Our ref: OUT22/19551

9 November 2022

Subject: **New England Solar Farm Modification 2 (SSD-9255-Mod-2) - Modification Report**

New England Solar Farm
Surface water assessment
Figure 4.2

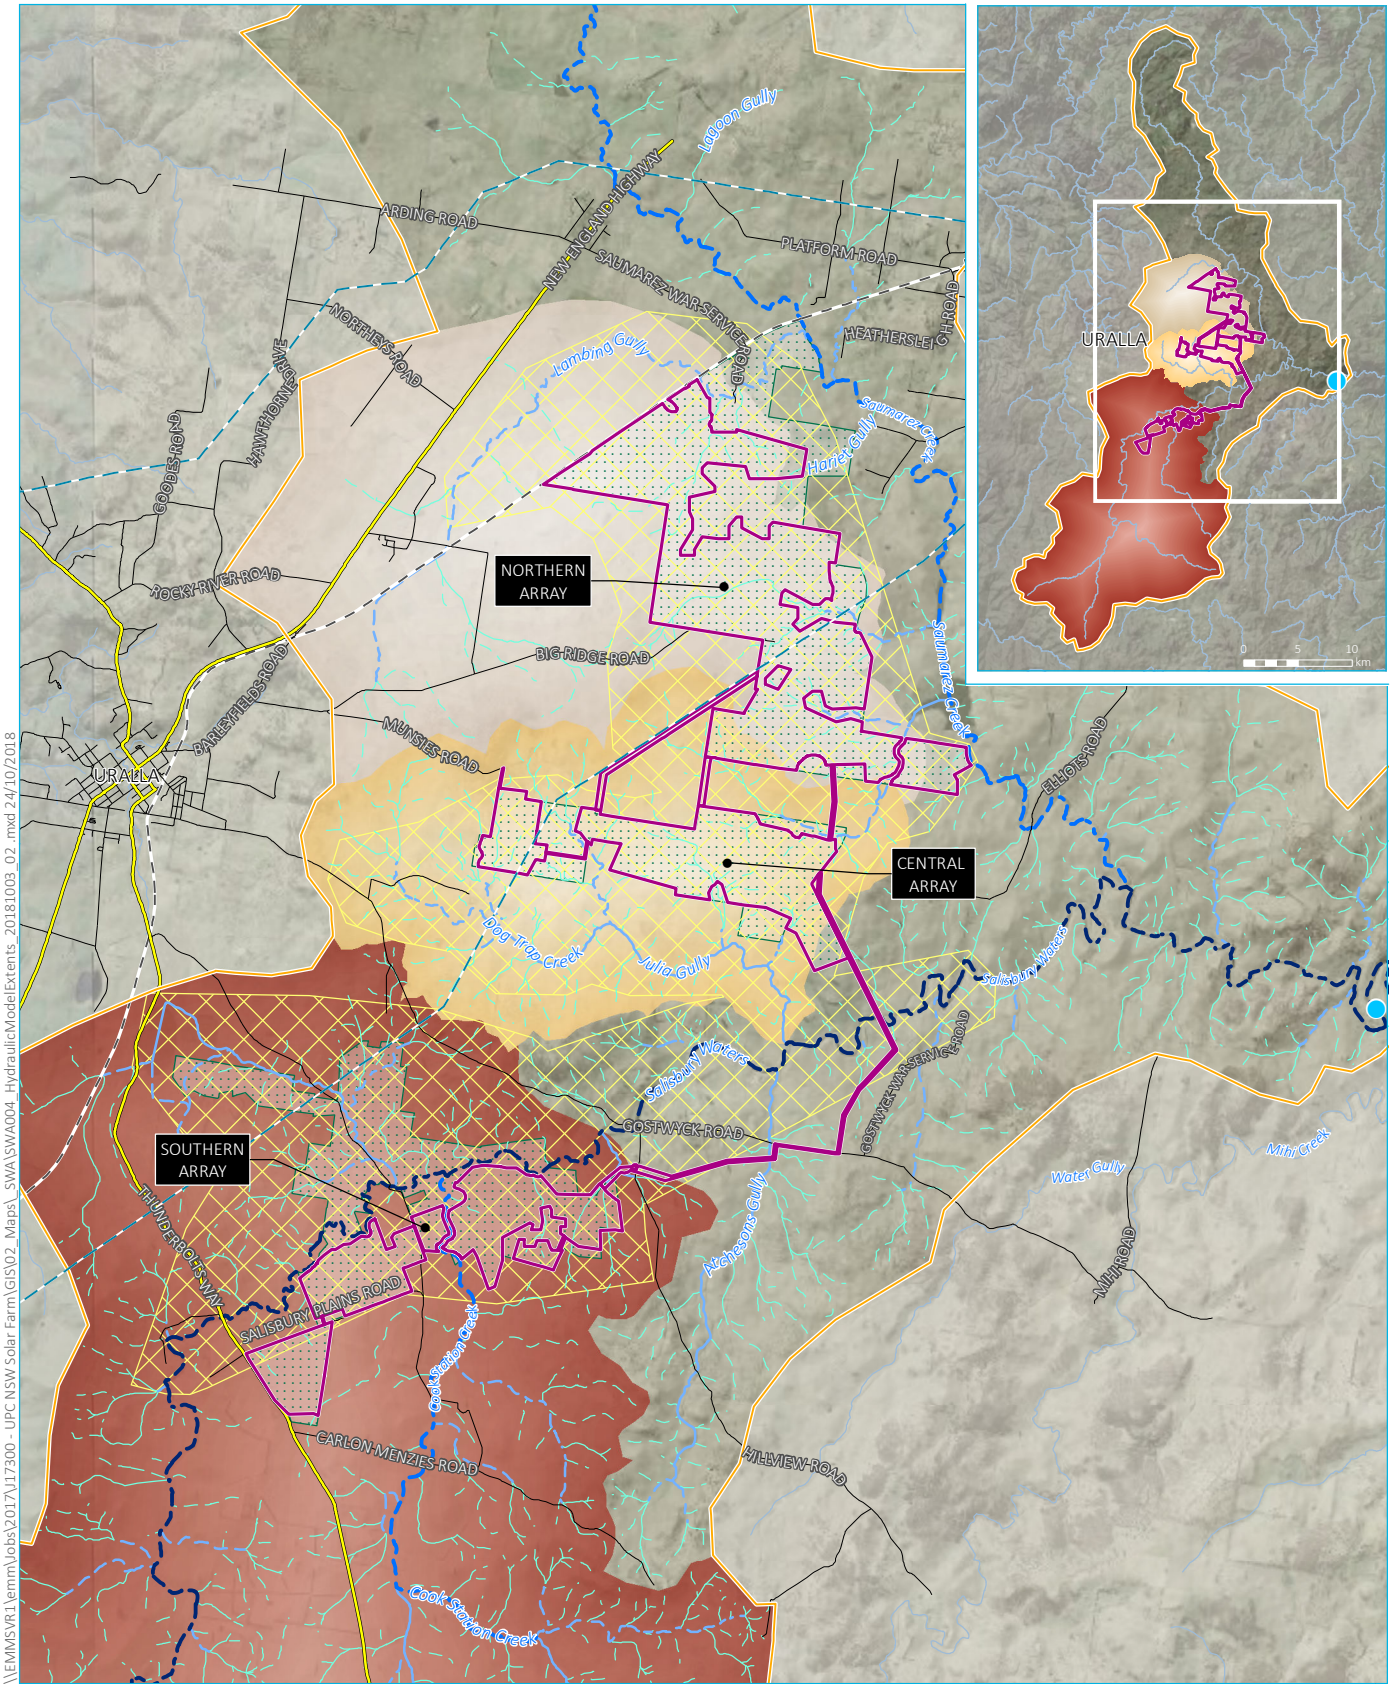
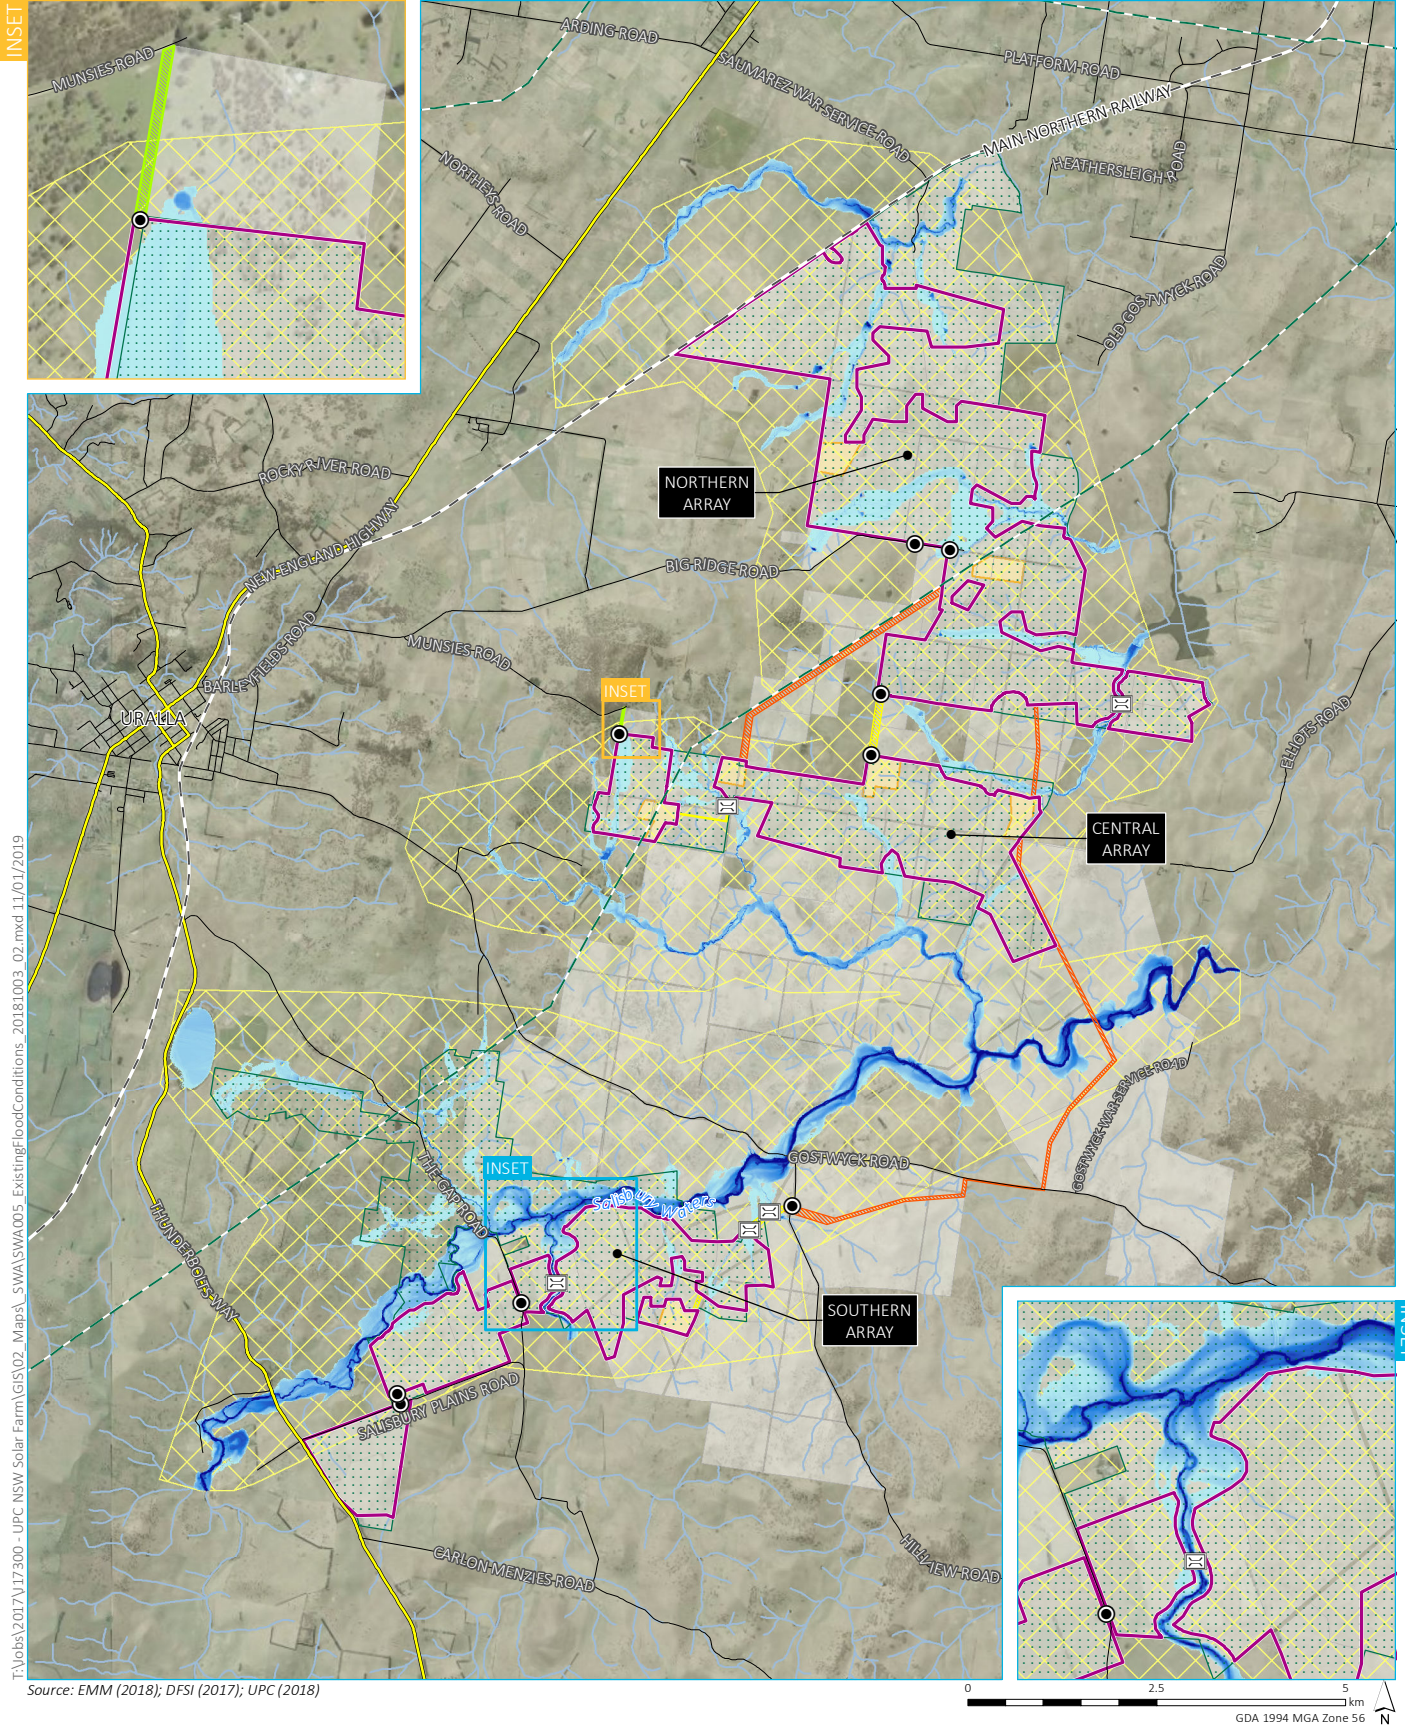
It is unclear if the additional lots covered in this proposal will have vegetated riparian zones (VRZs) or will be entirely covered in solar arrays. Figure 2 shows these areas as solar arrays but Section 3.1.2 and Figure 3.2 indicate that there are setbacks for watercourses in accordance with the Guidelines for Controlled Activities on Waterfront Land – Riparian Corridors. Clarification is requested on the proposed use (and management, if required) of these areas.
